**Subject:** Notice of Exhibition for Barangaroo South 1A Subdivision (Third Phase) (SSD 8997)

From the information submitted, the following information has **not** been provided in the Plan of Subdivision as per the SEARs:

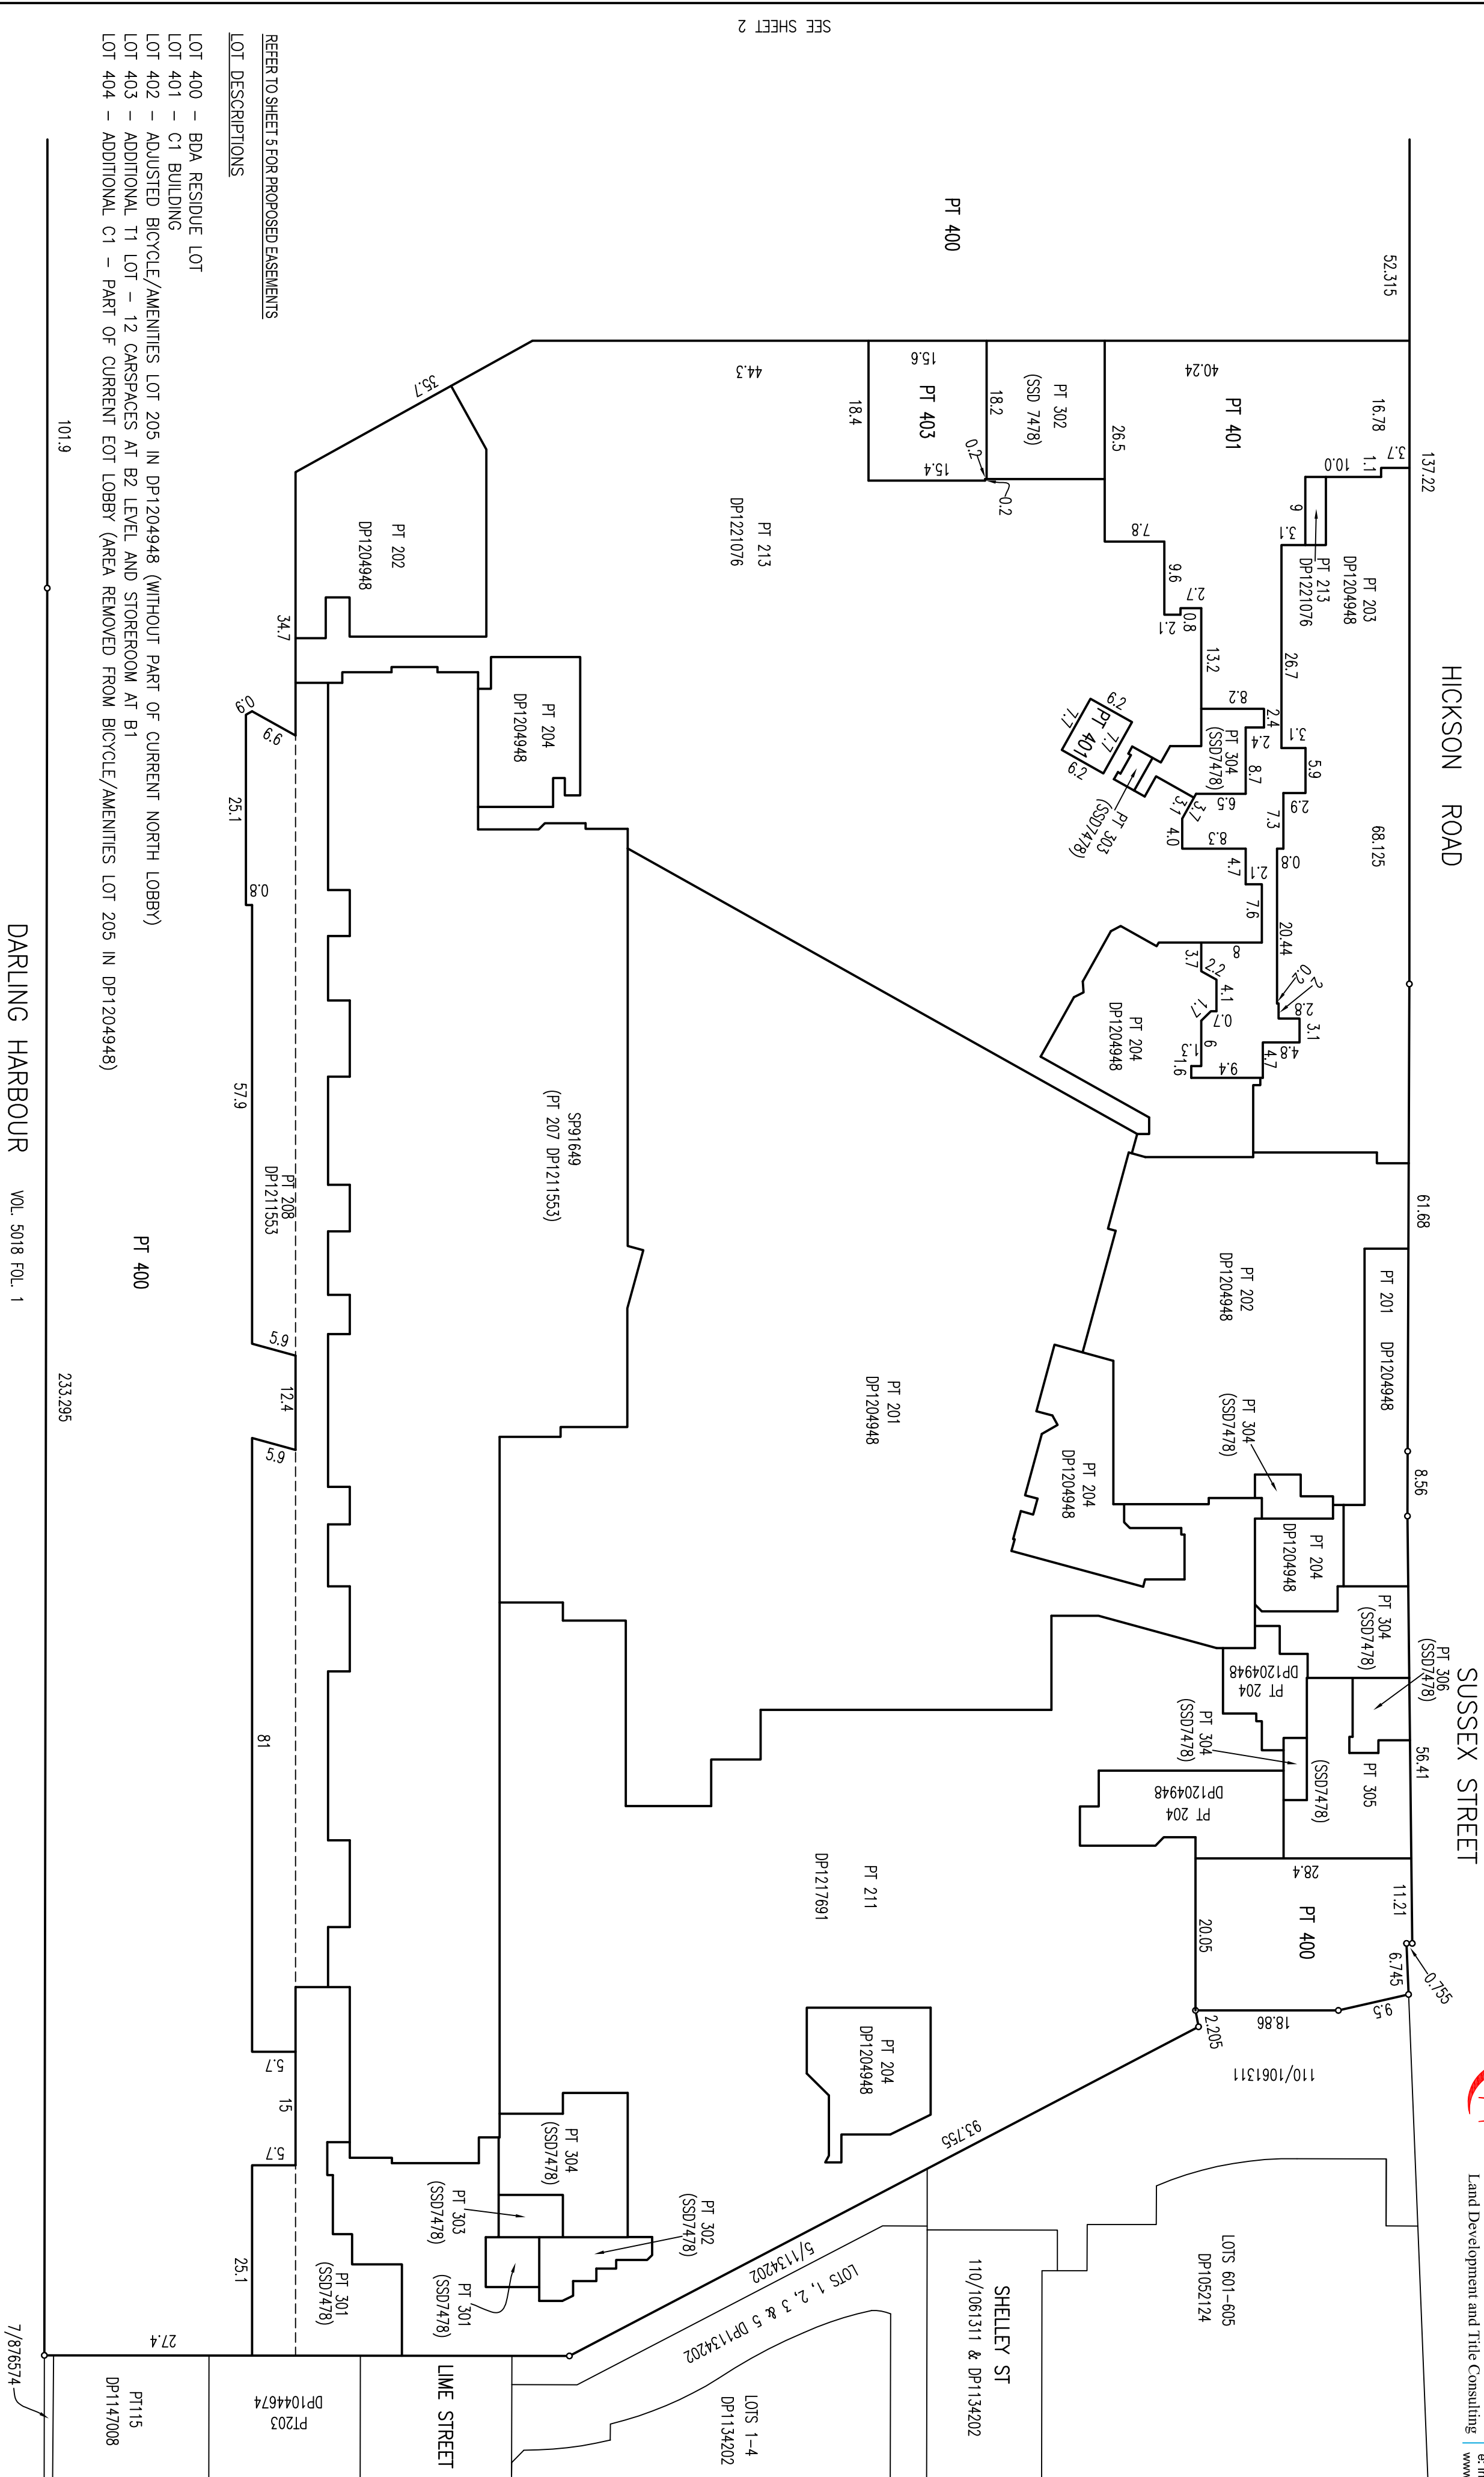
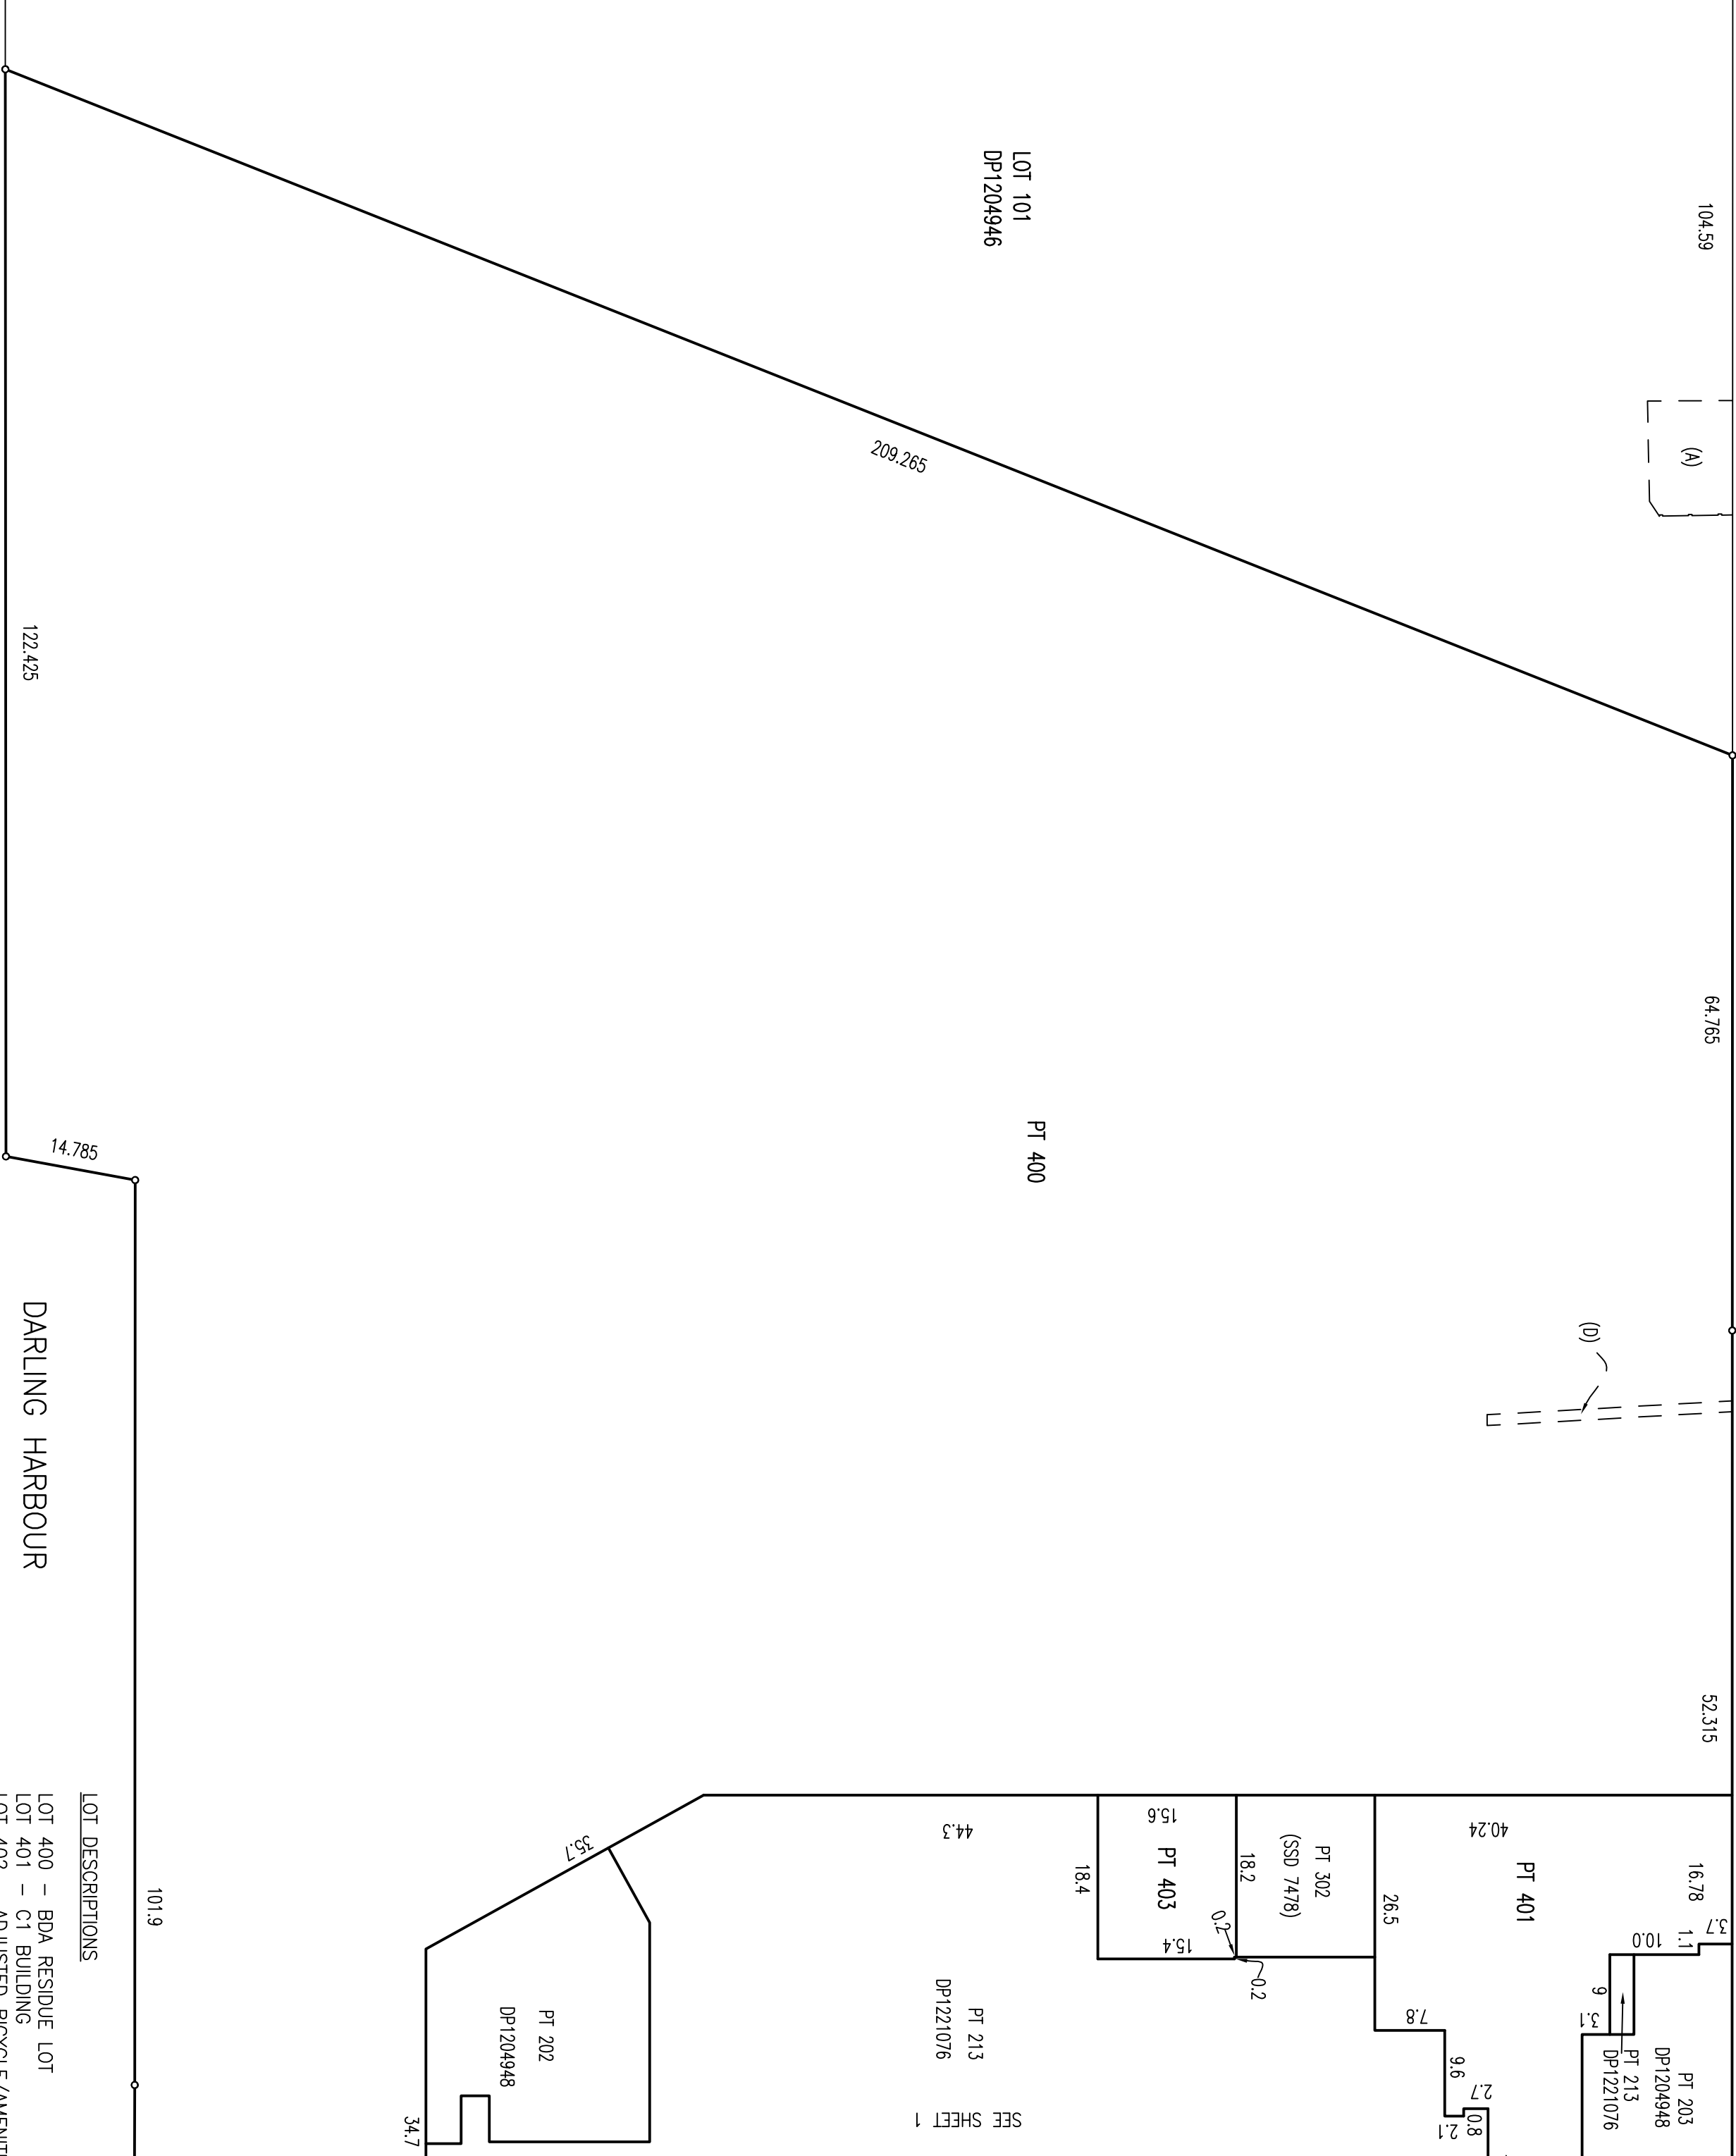
- **no details of any covenants, easements, notations, rights of way or the like proposed to ensure appropriate access is provided to each service provider to enable the on-going maintenance of their assets and to enable public access to the public domain areas have been provided and**
- **the information does not include a draft Section 88b instrument and a building management statement where relevant.**

The plans do not show any easements or covenants, therefore the Department should ensure:

- Compliance with SEARs.
- Compliance with previous approval for the development of the site. For example, full compliance must be given to the conditions of the SSD development consents contained within the Instrument of Approval, and as subsequently amended, in relation to the development of the subject site where applicable to this subdivision.

- Easements under Section 196 of Conveyancing Act: Documentary reciprocal easements for services, drainage, support and shelter, and emergency egress, affecting the whole of each lot if so desired, must be created over the lots in the subdivision, pursuant to Section 88B of the *Conveyancing Act 1919* and to Council's satisfaction.

- Additional easements: Any other documentary easements or any other encumbrances and indemnities required for joint or reciprocal use of part or all of the proposed lots as a consequence of the subdivision must be created over appropriate lots in the subdivision, pursuant to Section 88B of the *Conveyancing Act 1919* and to Council's satisfaction.
